RE: Letter of Objection for planning application 3/2021/0660

I am contact you with regards to the planning application number 3/2021/0660, Grid reference: 369068 450229.

We have been in contact with United Utilities following the proposed works for the Bowland section of the Haweswater Aqueduct Resilience Project, which I believe will have significant implications on our residential dwelling, the local environment and economy, and the health and welfare of those in the area.

0	SP	LH	SH	Initial Issue	4/26/2021
VERSION	AUTH	CHKD	REVD	REASON FOR ISSUE	DATE

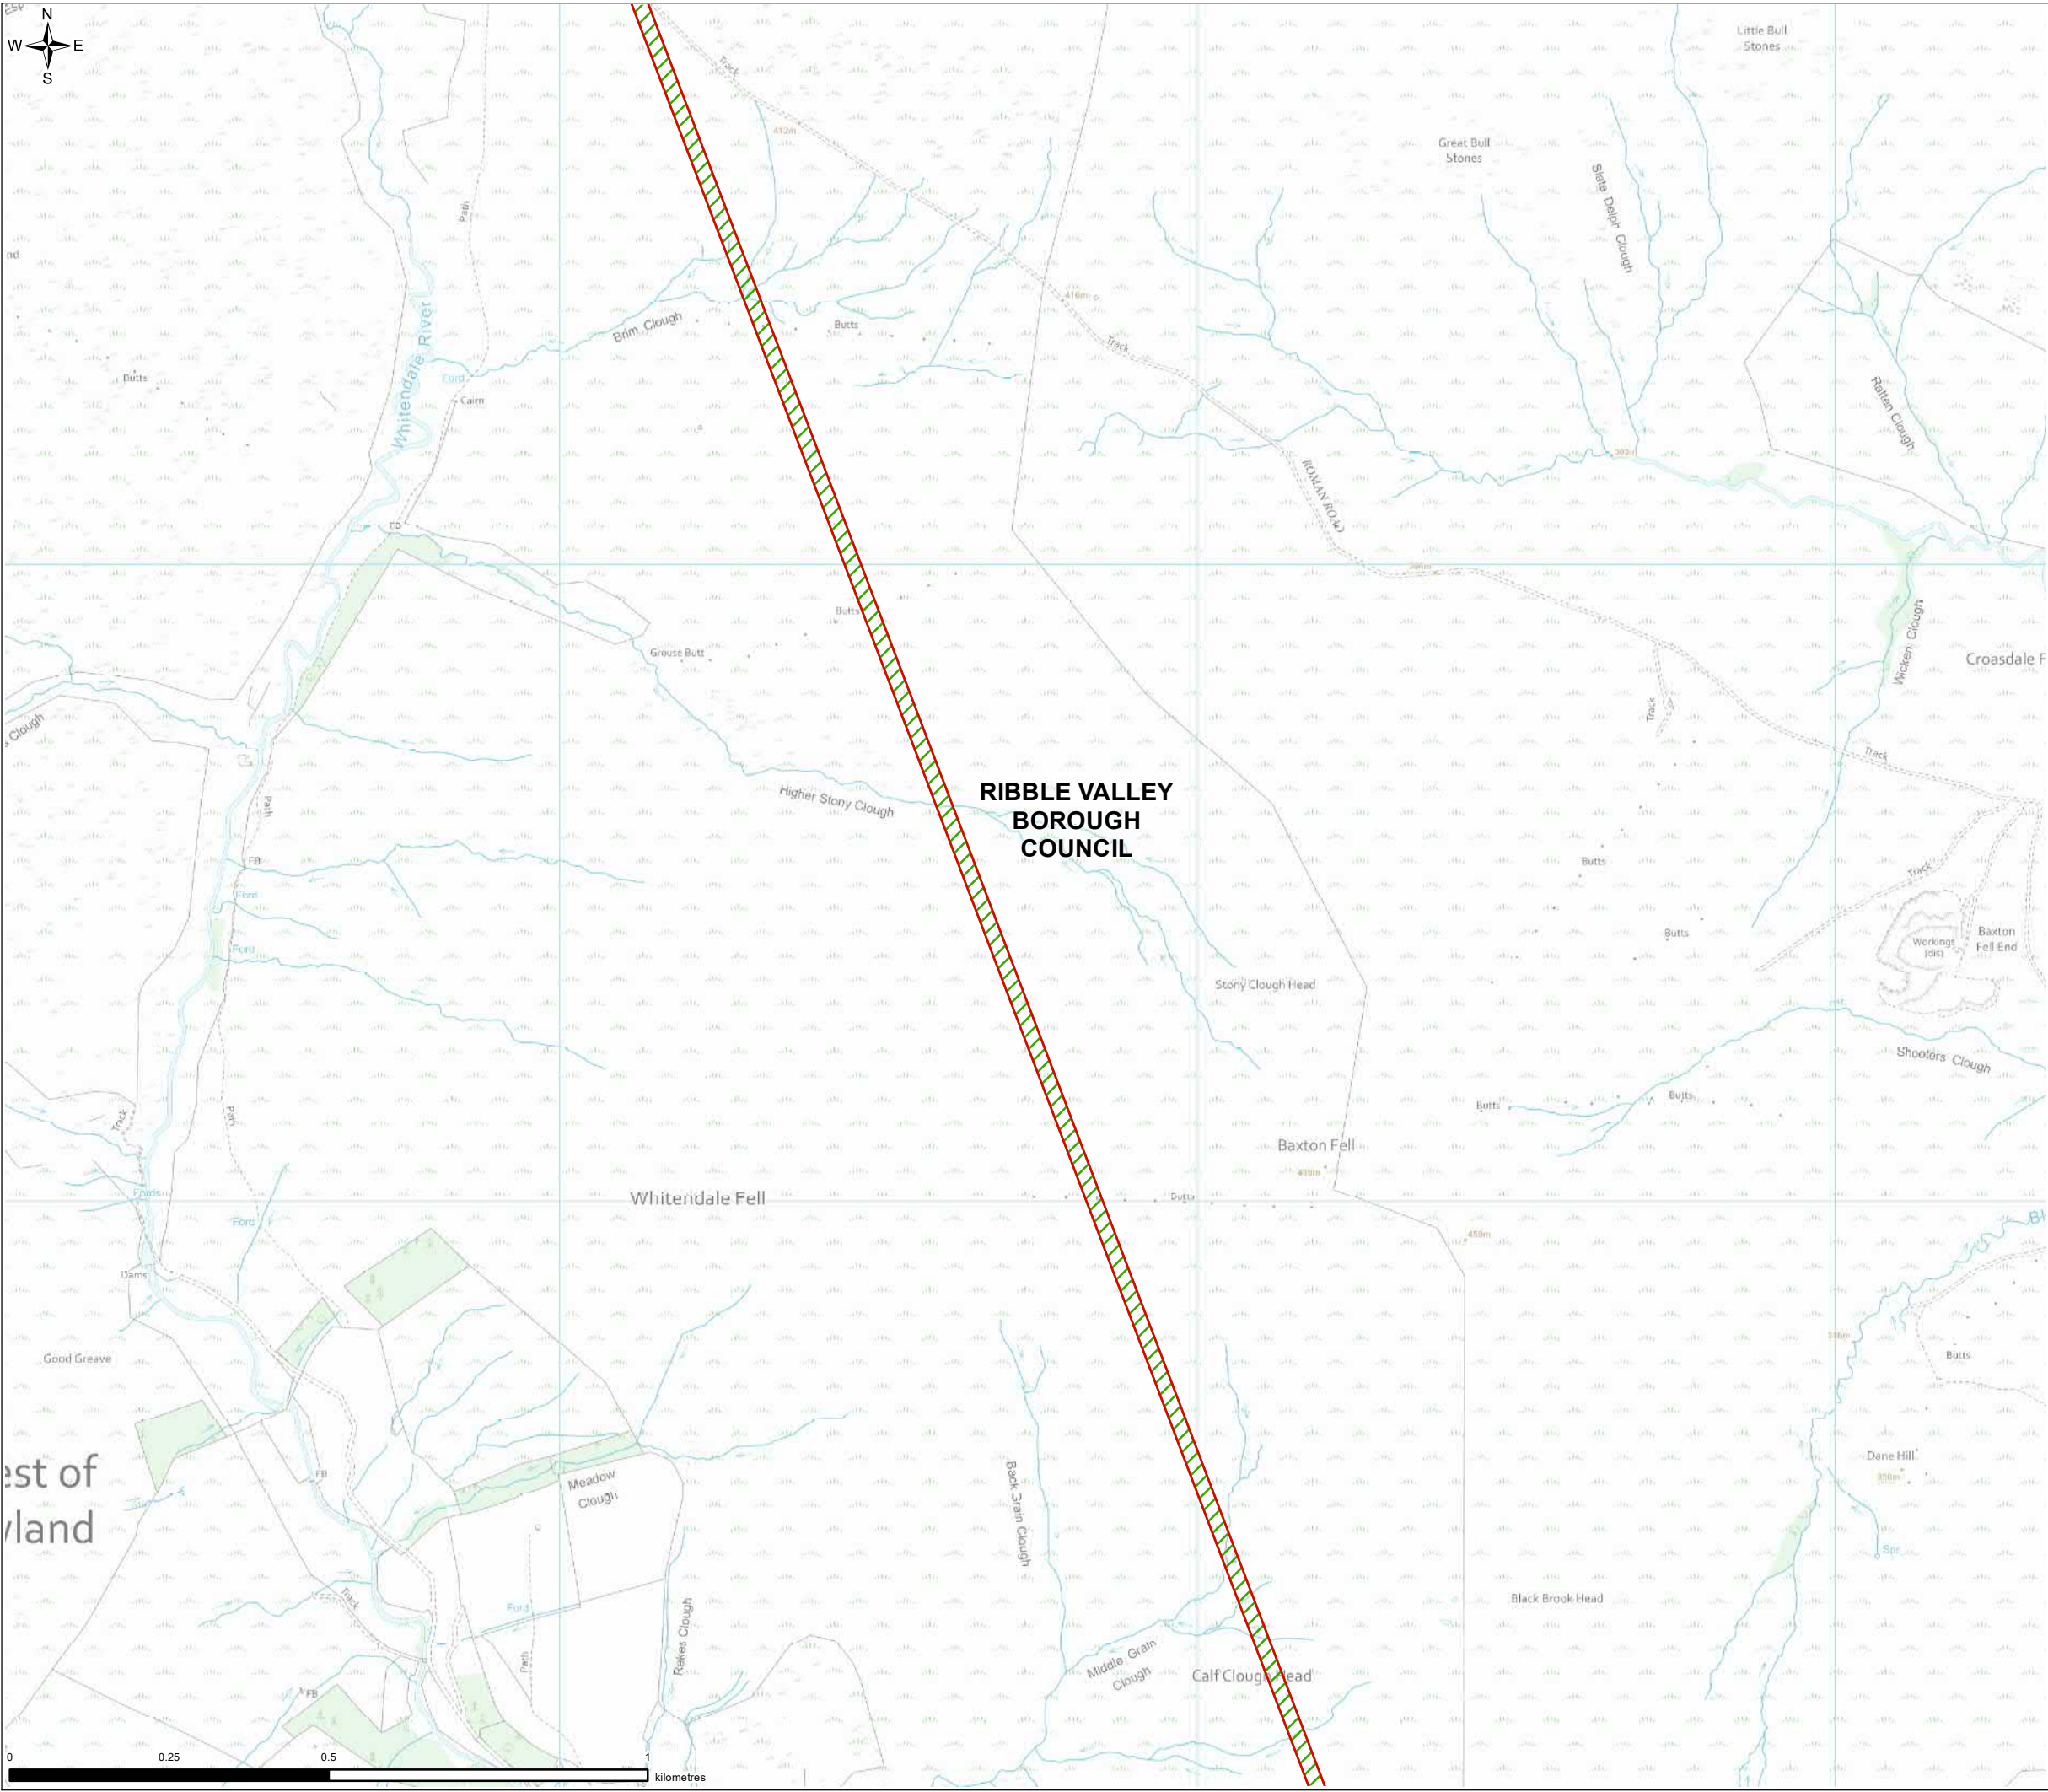
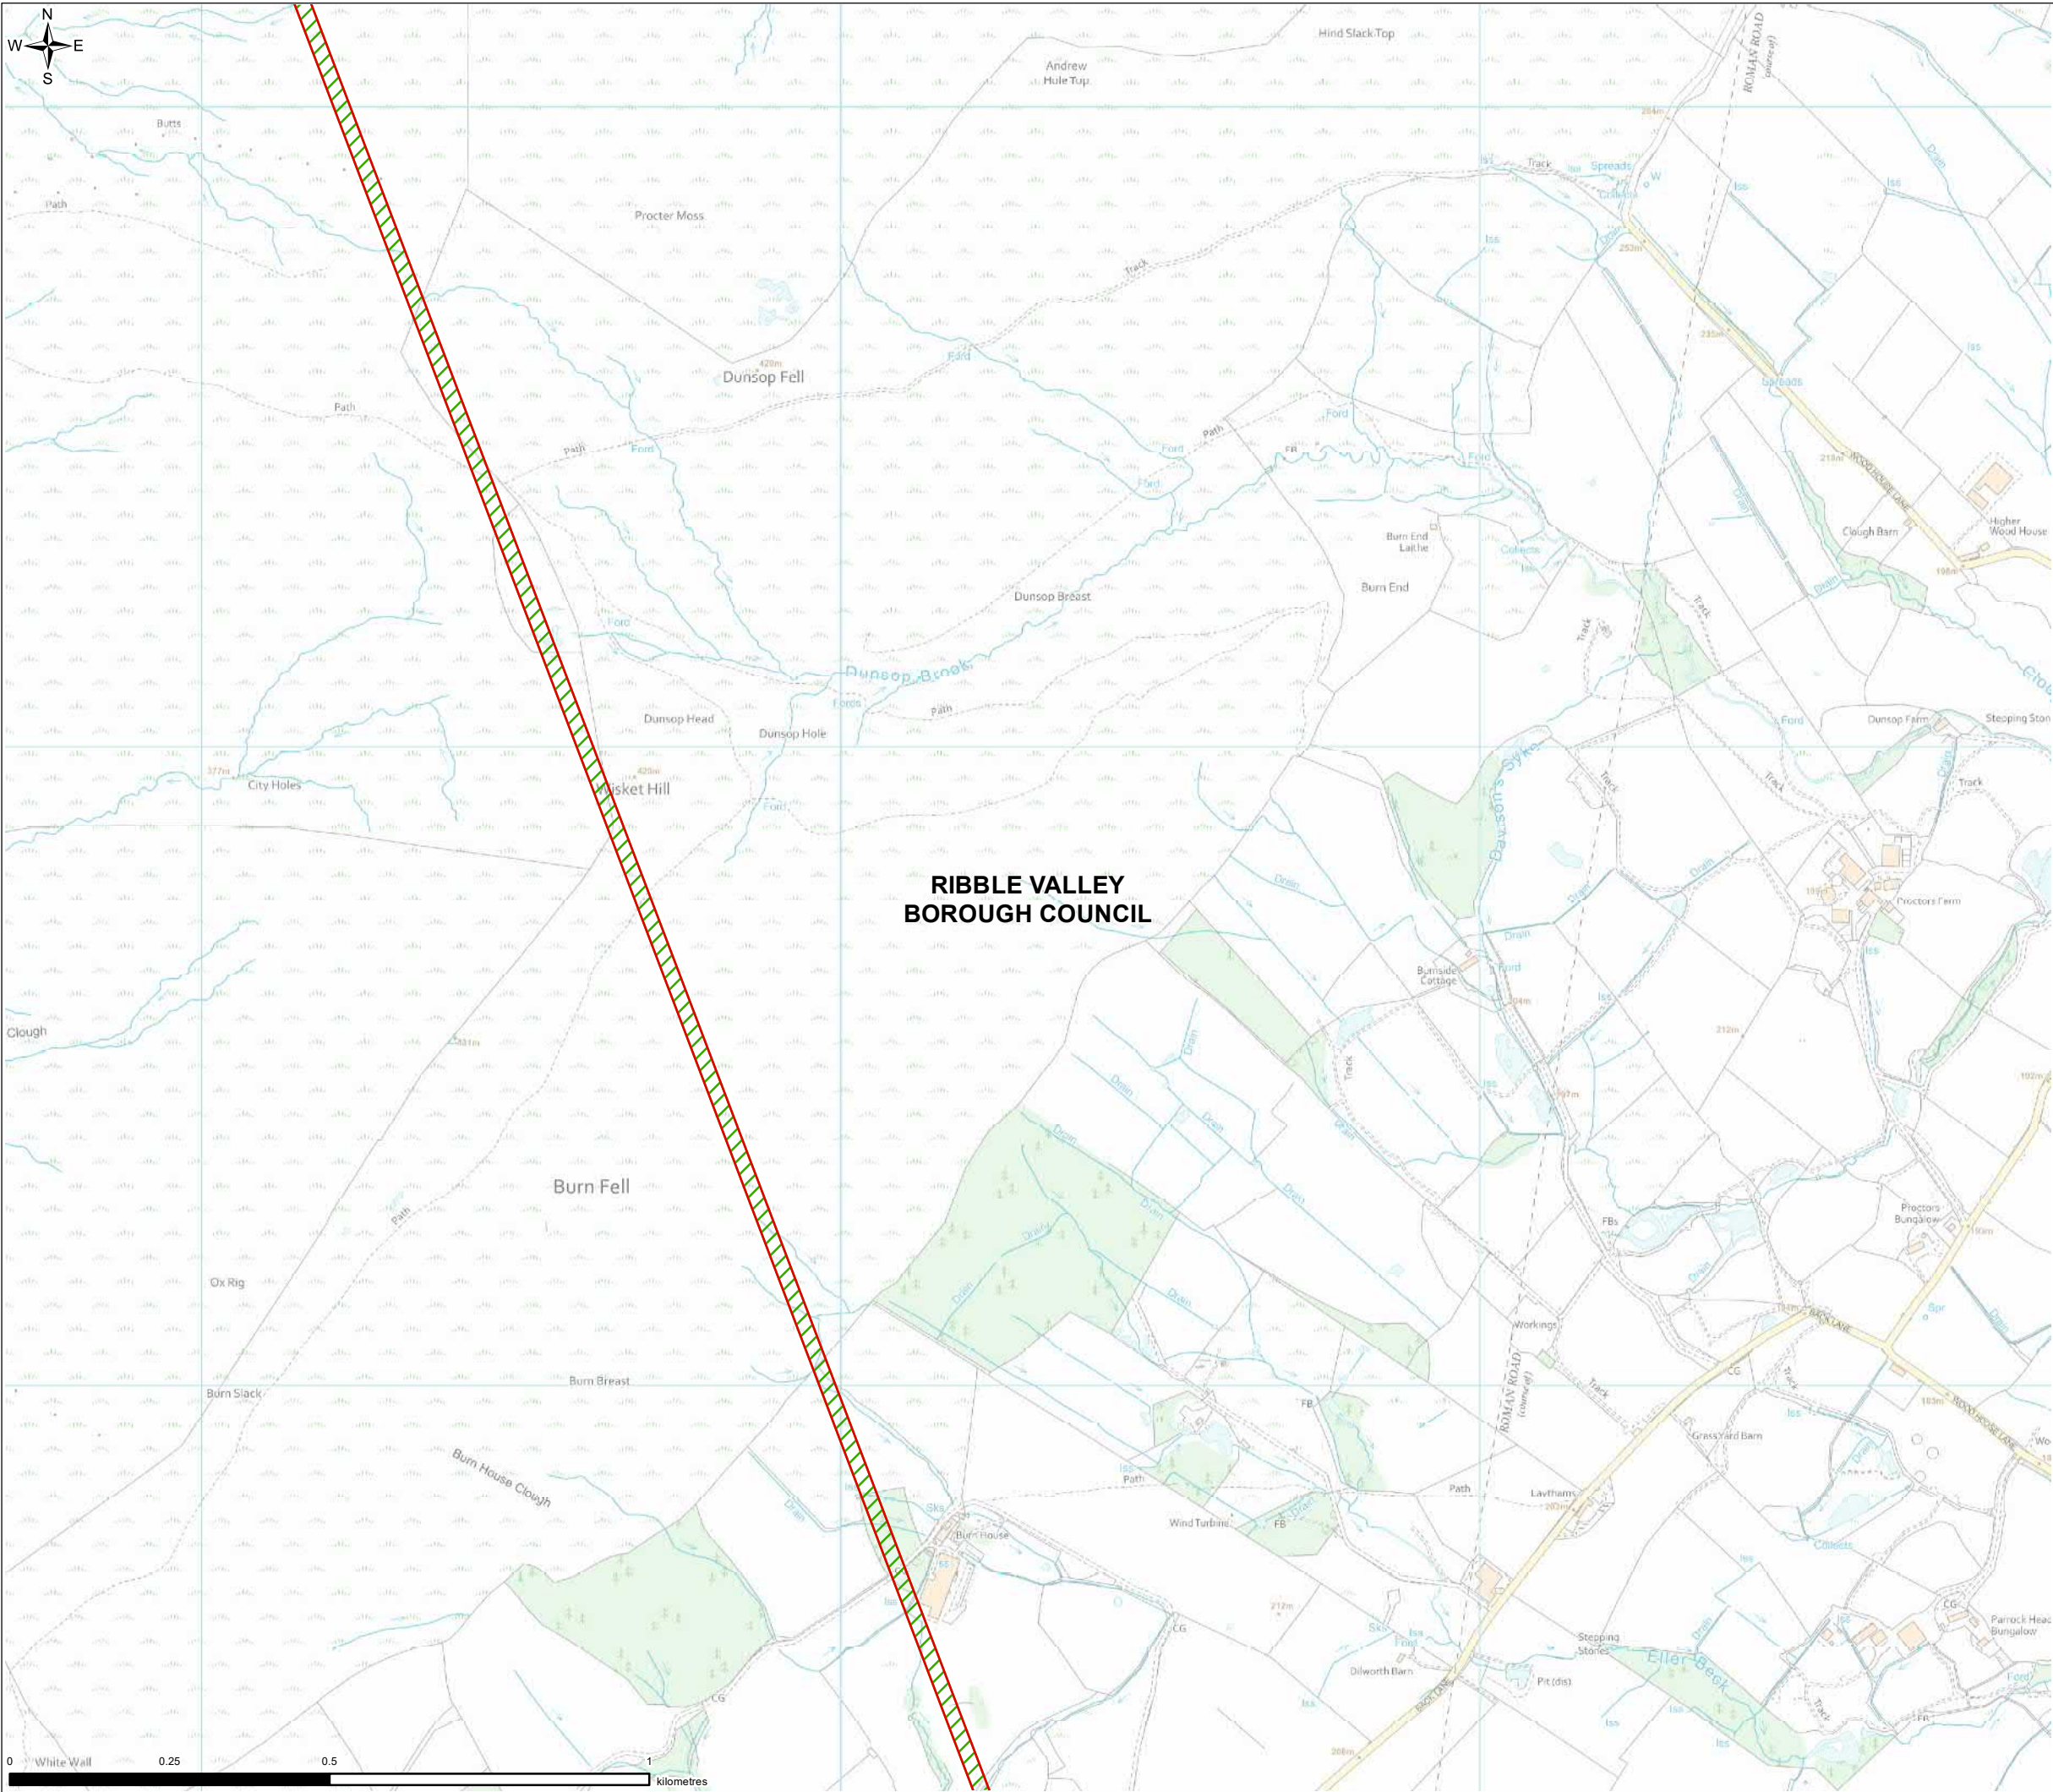
The estimated 24m buffer strip, which is the estimated boring path has moved since the original proposal United Utilities approached us with in 2019. At this stage, preliminary ground works in the form of geophysical vibriosis monitoring was done in order to estimate the ground composition prior to works. The original path and plan followed Backlane and went right by This plan has however changed in the new proposal and as such, in the planning application.

From the map below, the new bore route is closer which raises concerns with regards to building subsidence. United Utilities have stated that this is "Unlikely" but as they do not know what sort of terrain they are entering, anything is possible. If they hit rock, the vibrations alone even 100m down have the potential to cause on ground issues with building foundations. What happens if subsidence occurs when the Although this is an upsetting thought, our main concern with the works is our water supply.

I am afraid that the new pipeline plan is dangerously close to [REDACTED]. As stated previously, the original plans we were sent followed the roadside, but this map indicates that the tunnelling will be [REDACTED]. Therefore, these plans will more than likely enter our water aquifer, which the water table sits approximately from 90ft to 285ft deep, with a 110ft sleeve.
